From: Richard Temple
Sent: 08 February 2018 09:21
To: Karen Parsons
Subject: FW: Application LU/323/17/PL - Maltravers Road, Littlehampton, BN17 5NA

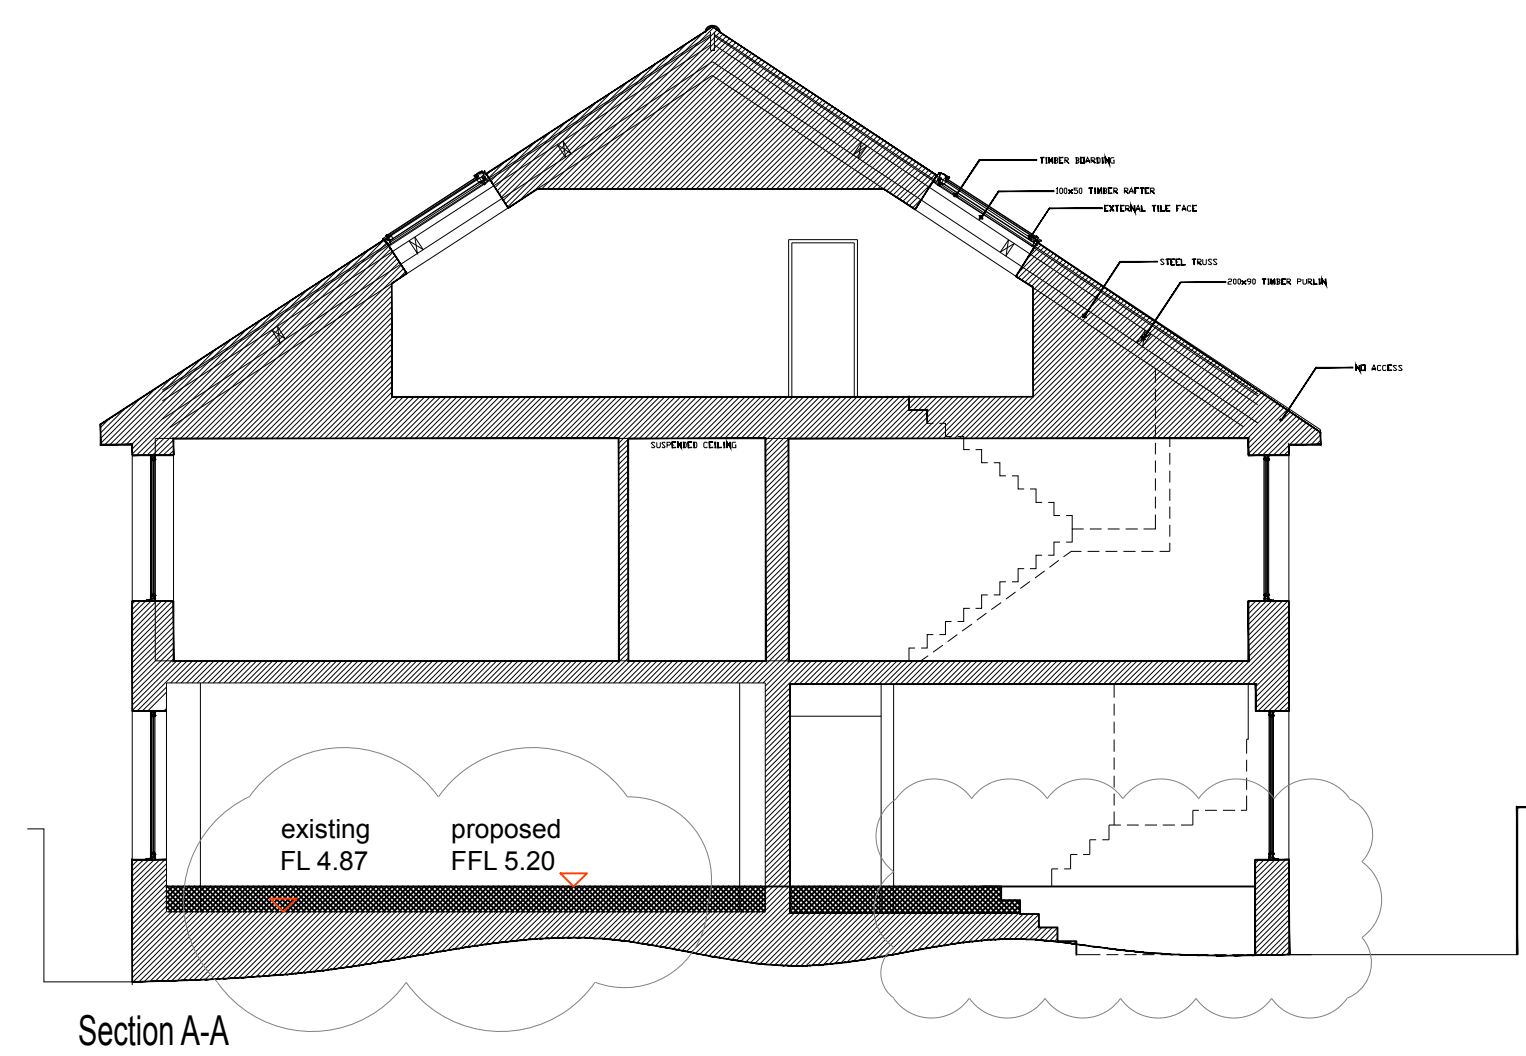
From looking at the sections on drawing number PL.003 Rev. B, if you were to agree obscure glazing of just the lower half of the proposed windows, that would be up to 1.9m (approx) anyway. As such, we can condition to obscure glaze and fix shut to 1.7m. As this is the case we do not have objections on the grounds of residential

amenity for the overlooking or the flat at ground floor next to the access lane to east. Please can you send in amended drawings and section showing this?

Would a 60/40 split mean obscure glazed to 1.7m above finished floor level? We would want at least 1.7m obscure glazing.

I attach the amended plans re the windows. This should now address the amenity point you have raised but please advise.

I am confident the 60/40 split will overcome your concerns but if not we will ensure that the obscure element is up to 1.7m with a clear glassed fan light above.
